From: Amanda Scholes on behalf of Planning.Responses
Sent: 28 June 2019 09:39
To: Planning Scanning
Subject: FW: LU/96/19/CLP

From: Mark Burchett [REDACTED] >
Sent: 27 June 2019 07:50
To: Finlay Gardner [REDACTED]
Cc: [REDACTED]
Subject: RE: LU/96/19/CLP

I am emailing regarding the lawful development certificate for a single store rear extension. As it is from the information available it is set to be refused. This is due to the materials that are proposed to be used. The GDPO explains that the materials that should be used should be similar to those of the existing, from what I can see it seems the windows are White PVC not grey aluminium slim profile- walls are red brick not smooth white render and low level blue grey brick- roof seems to be red tiles rather than fibre cement slates.

Proposed Rear Elevation (East)
1:100

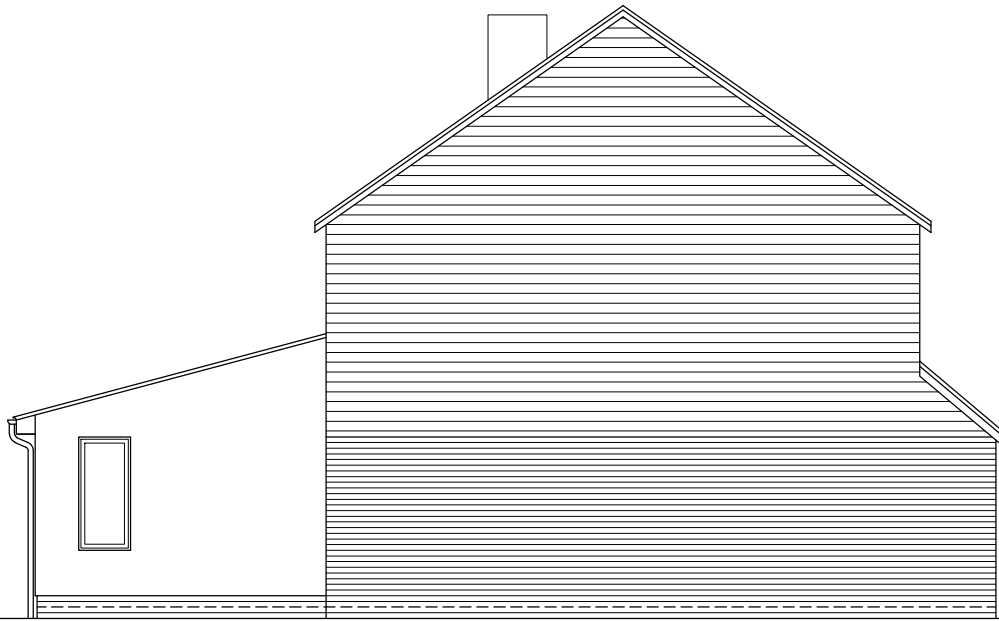
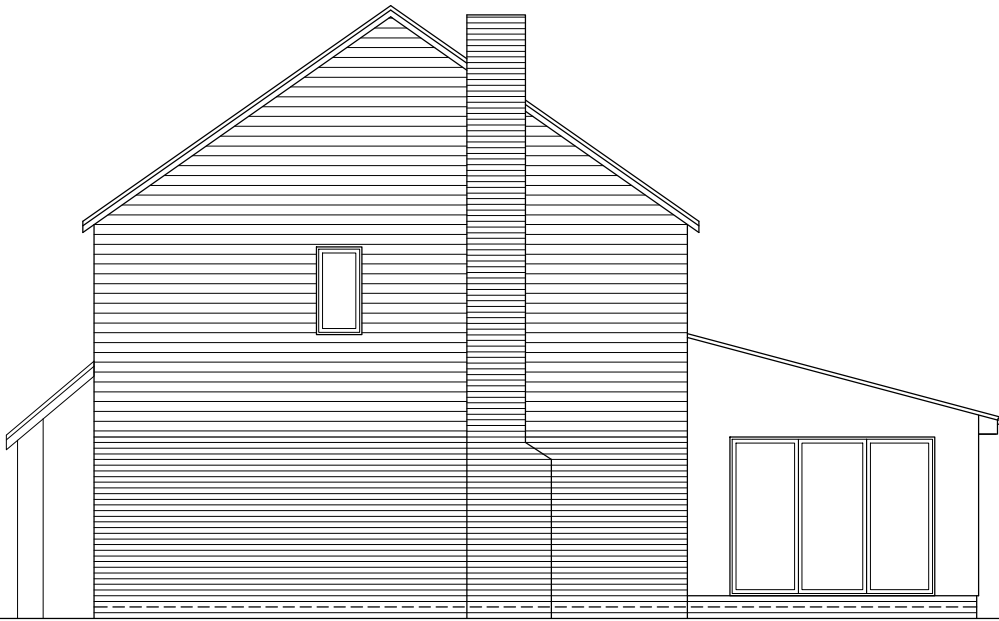
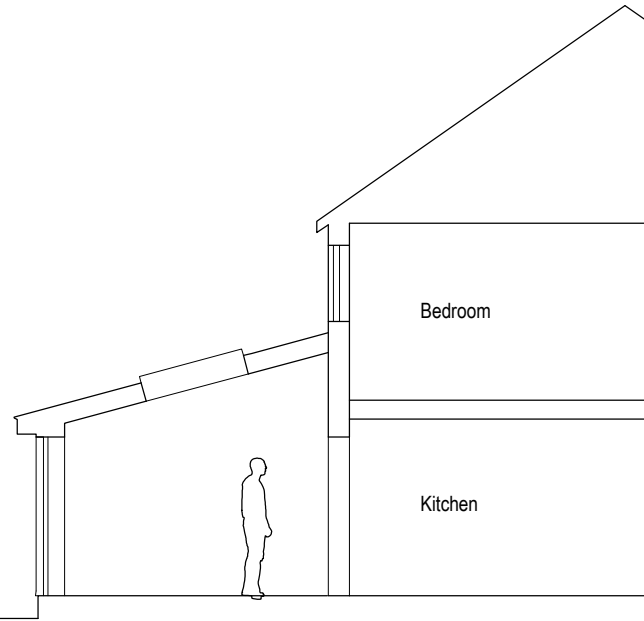
SCHEDULE 2 Part 1 a.3 (a) of the GDPO states that 'the materials used in any exterior work (other than materials used in the construction of a conservatory) must be of a similar appearance to those used in the construction of the exterior of the existing dwelling house.'

This means that where the materials proposed are not of a similar appearance to those used in the construction of the exterior of the existing dwellinghouse, as they are proposed in this case, then the application would need to be refused. If you wish to pursue this use of materials then you will have to submit a planning application.

The proposed windows/doors will be white aluminium which i trust you agree are similar in appearance to those used in the construction of the exterior of the existing dwelling house.

If you would be prepared to amend the materials to something similar to (or the same as) existing then I would be able to approve the certificate as all other aspects tick the needed boxes.
